Case Officer Mr Z Denton
Case reference AB/109/20/HH
Extension - White Cottage 32 King Street Arundel BN18 9BW
Objection
Planning online comments ref: OWPC31410 (part one) and OWPC31411 (part two)
With supporting attachments

Updated Plans 'C' – confirming existing Objection remains

We have examined the revised plans (rev C) and elevations for White cottage. The level of the harm to the listed building at No. 36 King Street remains the same and our objections are as per our original letter dated 16th November 2020 (copy attached).

EASTERN ELEVATION

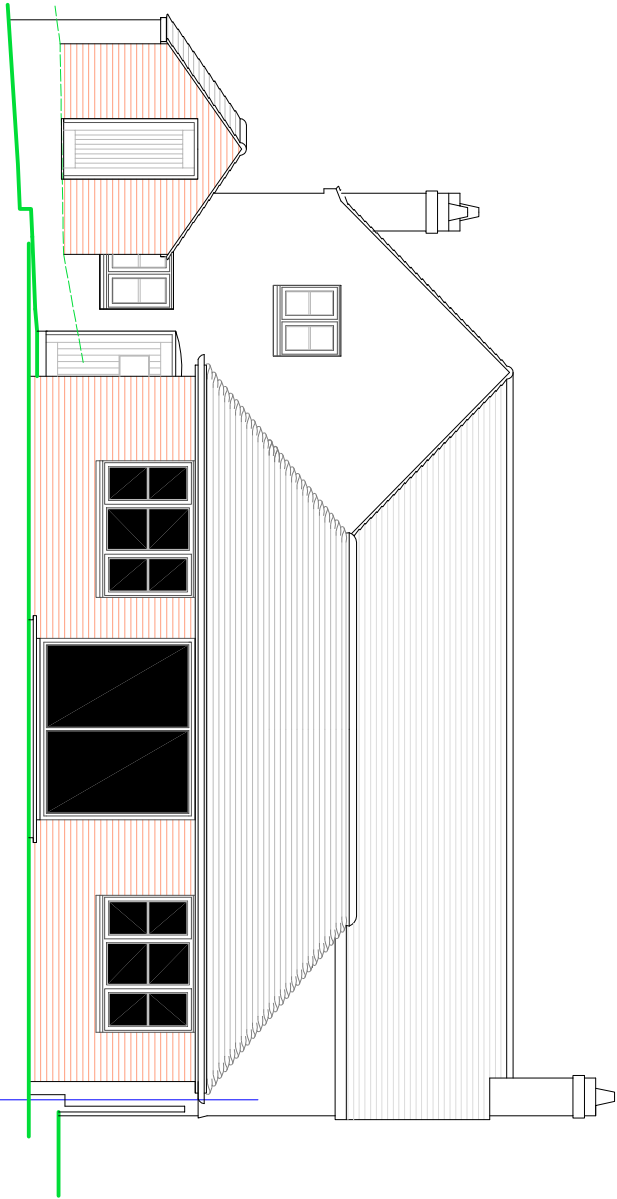
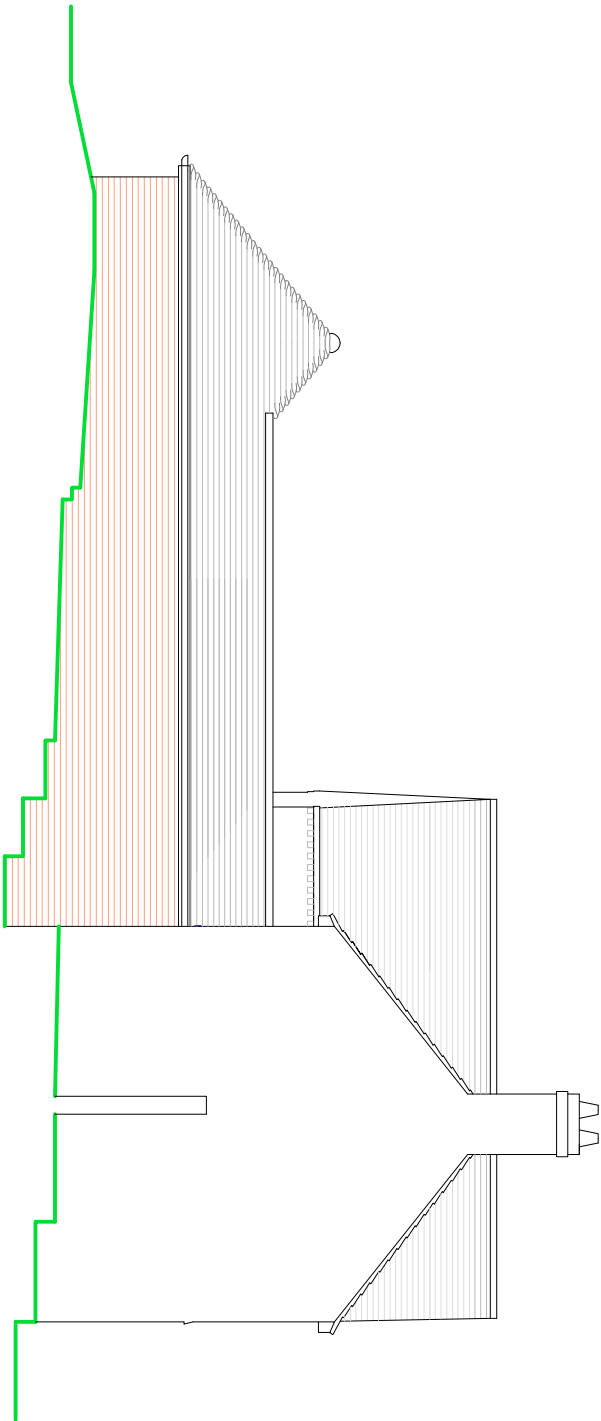
The proposal we consider to be in conflict with the Council's policies aimed at property with special character and ambience of listed buildings. The impact of the loss of amenity due to the proposed removal of the ancient beech hedge and its replacement with a 10 metre long blank wall would cause material nuisance, visual and amenity loss to our client of an unacceptable level and liable to be detrimental to human health. There would be significant loss of sunlight and daylight. We have calculated this in accordance with the Building Research Establishment Guide and BS8206-2

No 32/34, White cottage, was built with its Eastern wall held back for the preservation of light to the windows on the South elevation of the listed building at No, 36. Therefore No further construction can take place on the boundary between 32/34 and 36 as proposed. The height of the proposed wall would preclude light to all windows on the south elevation. This prescriptive right dates back to Circa 1690.
